State Significant Development Response to Submissions

31 Wheat Road, Sydney

Redevelopment of IMAX Building

March 2016 ■ 12255

Drawing
SK014.3

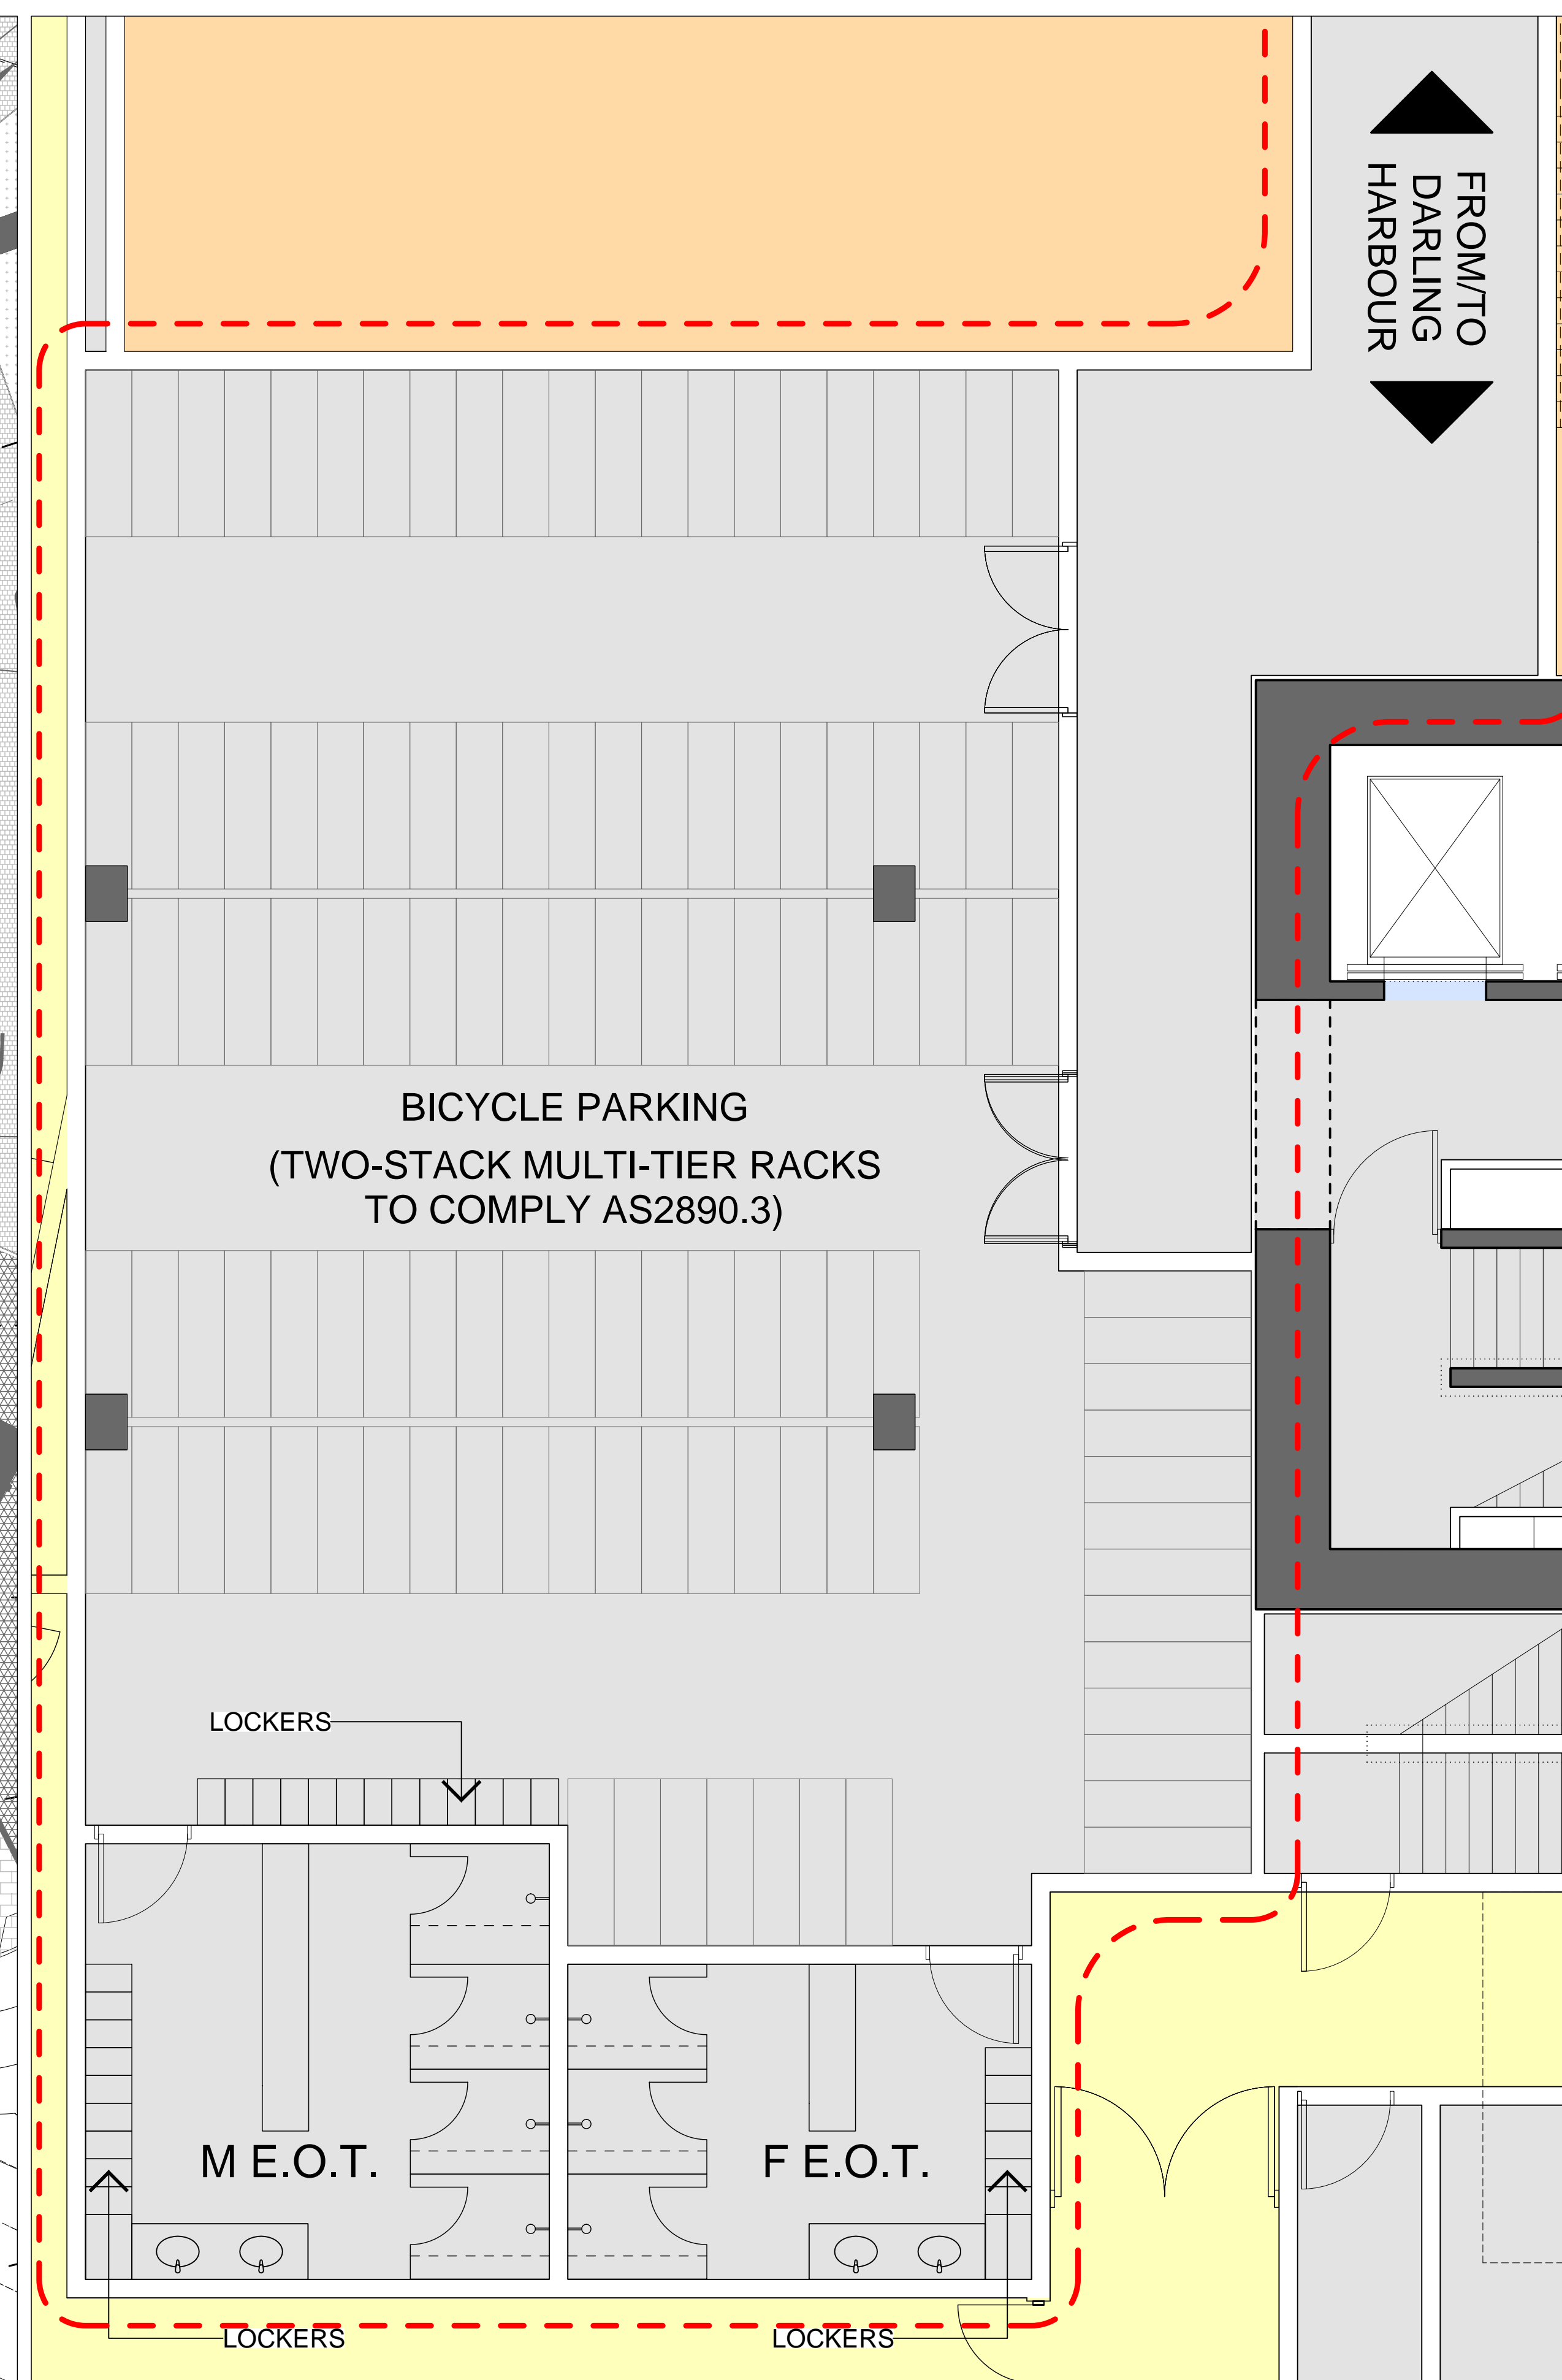
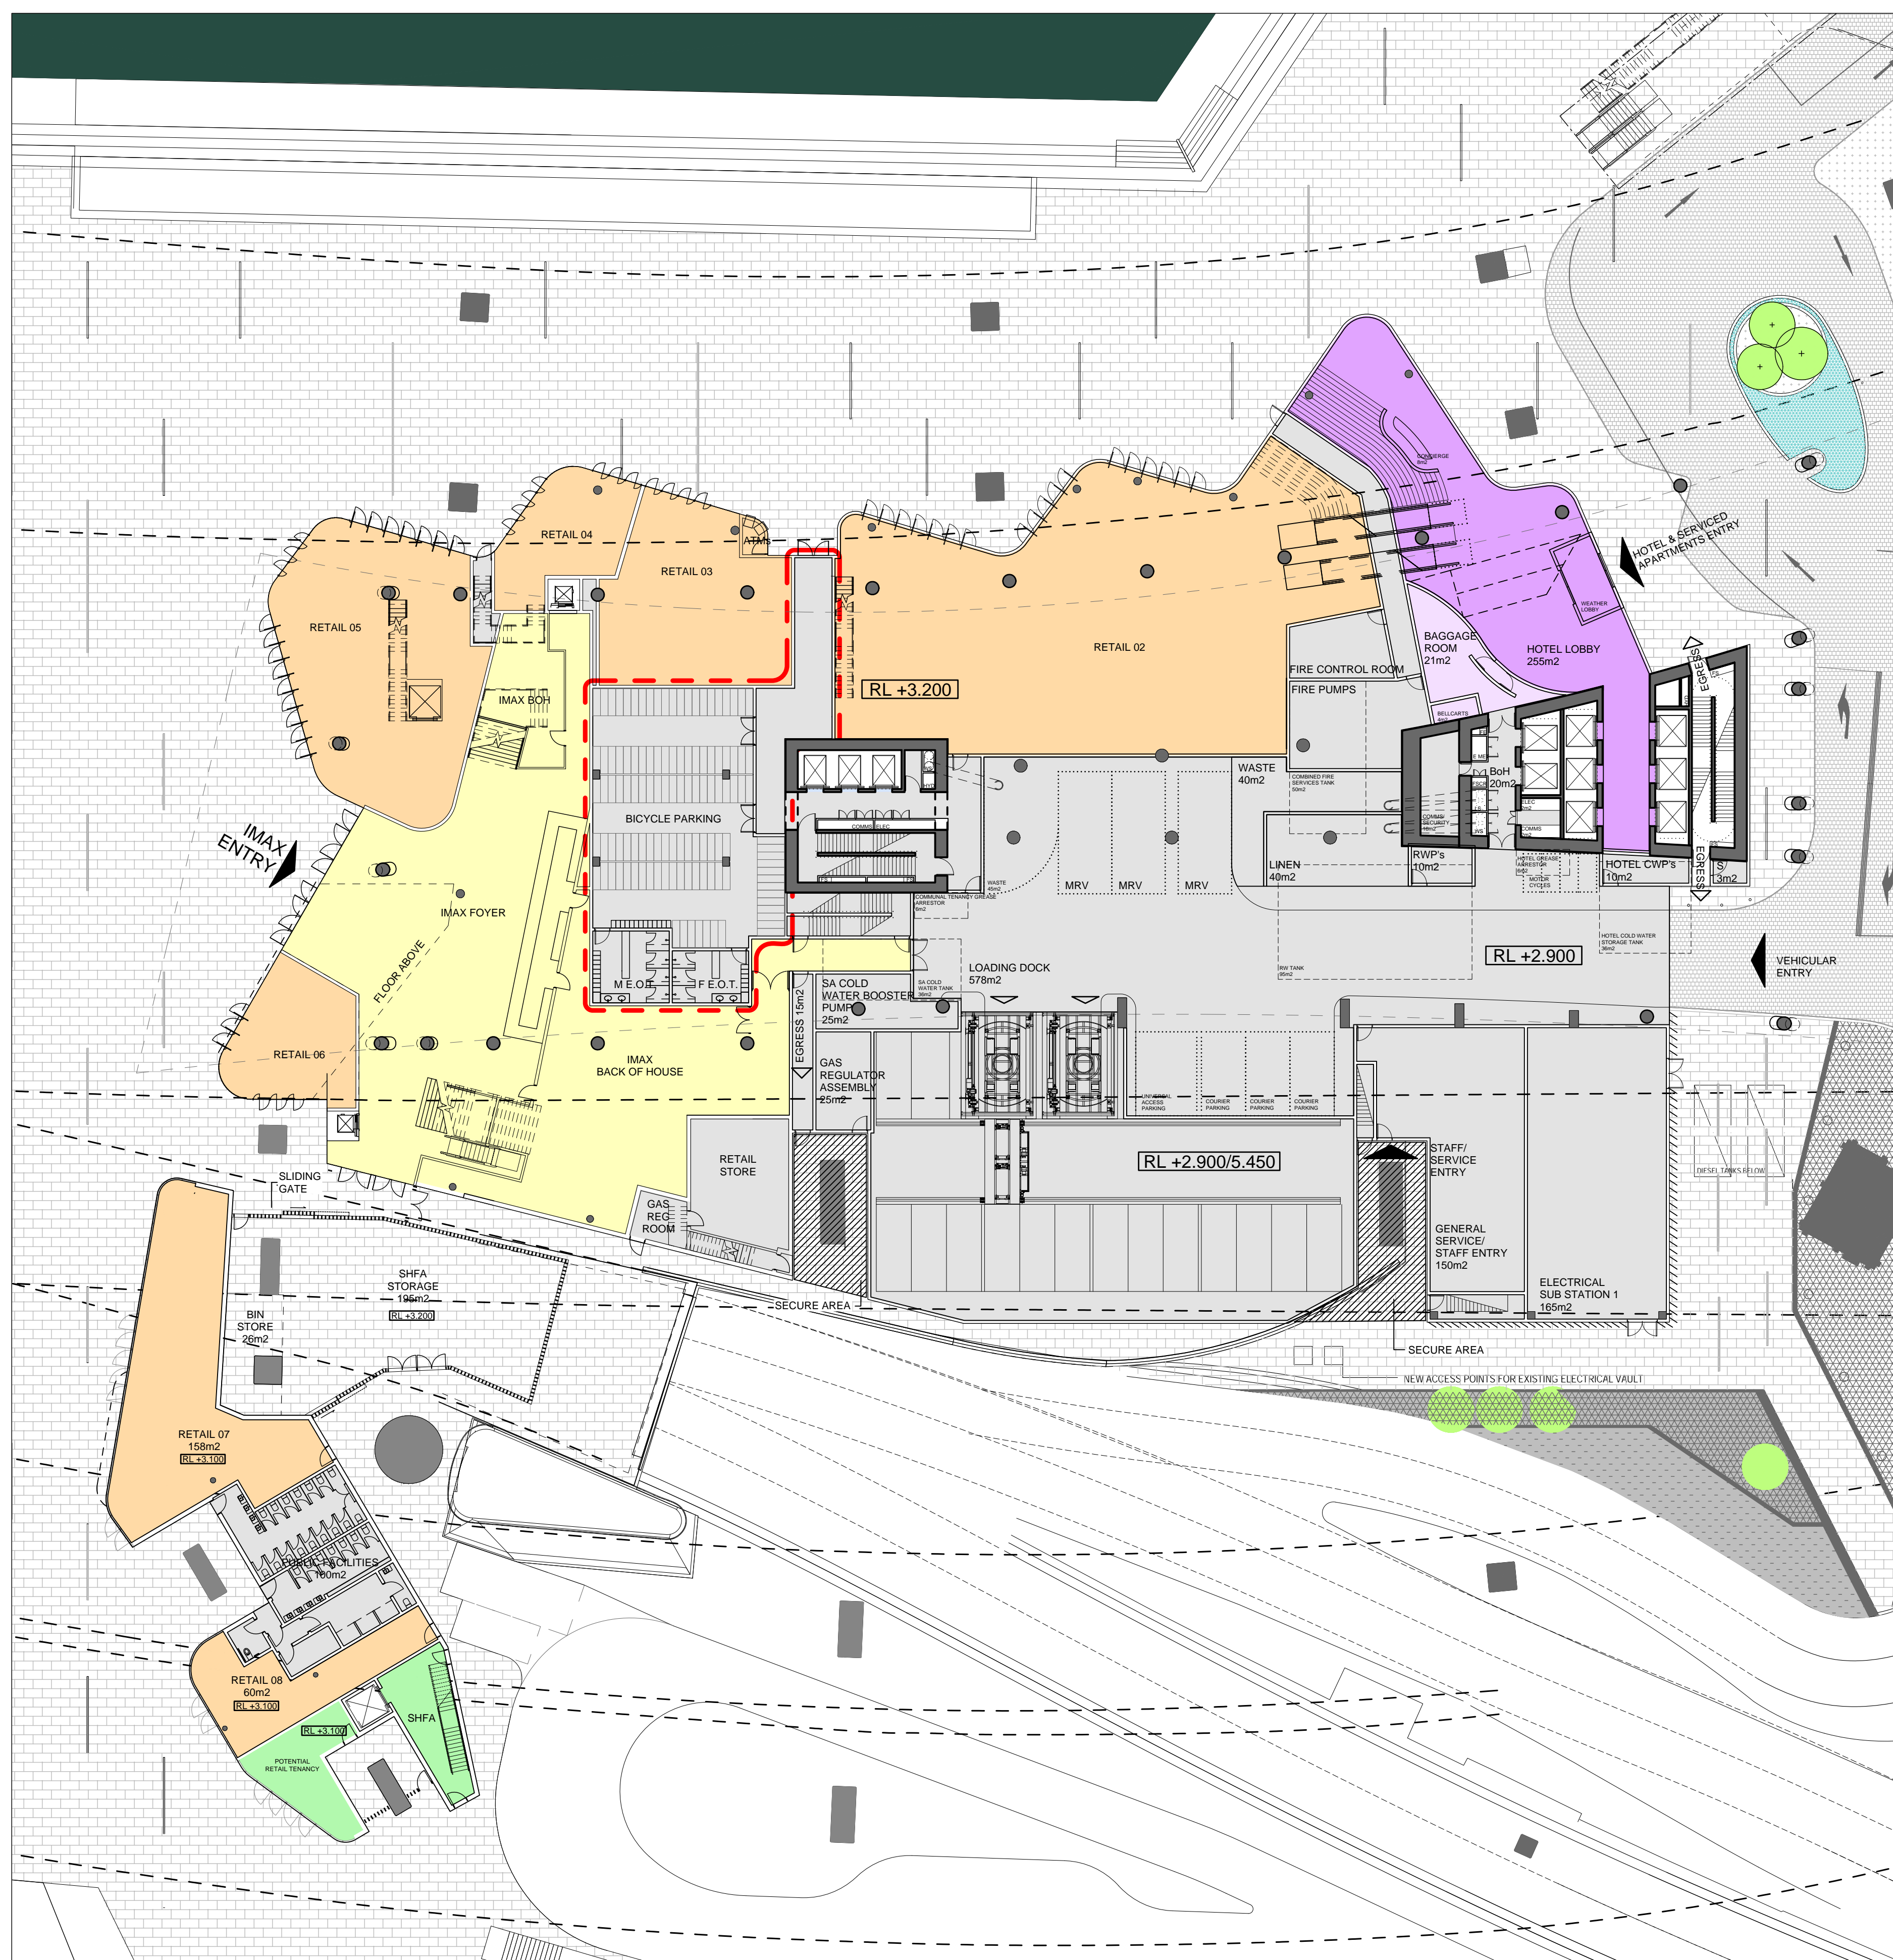
Concern was raised in relation to the potential of air intake louvres to disrupt the visual quality of the northern façade, and in particular at the podium level. To clarify this issue, no louvres are proposed on the northern facade. There is a single air intake proposed on the northern façade, however, this is not at podium level and will not be screened by a louvre. Rather, air will pass through via a system integrated with the curtain façade, with the glass panels set short of the mullions to allow air flow. With this system, it is not readily apparent that this portion of the façade allows for airflow, but rather its appearance is consistent with the surrounding facade.

To clearly show the architectural intent of the lower portion of the northern façade, additional photomontages have been prepared by HASSELL (SK014.1 to SK014.3, refer **Appendix C**). One of these montages is provided in **Figure 5** below.
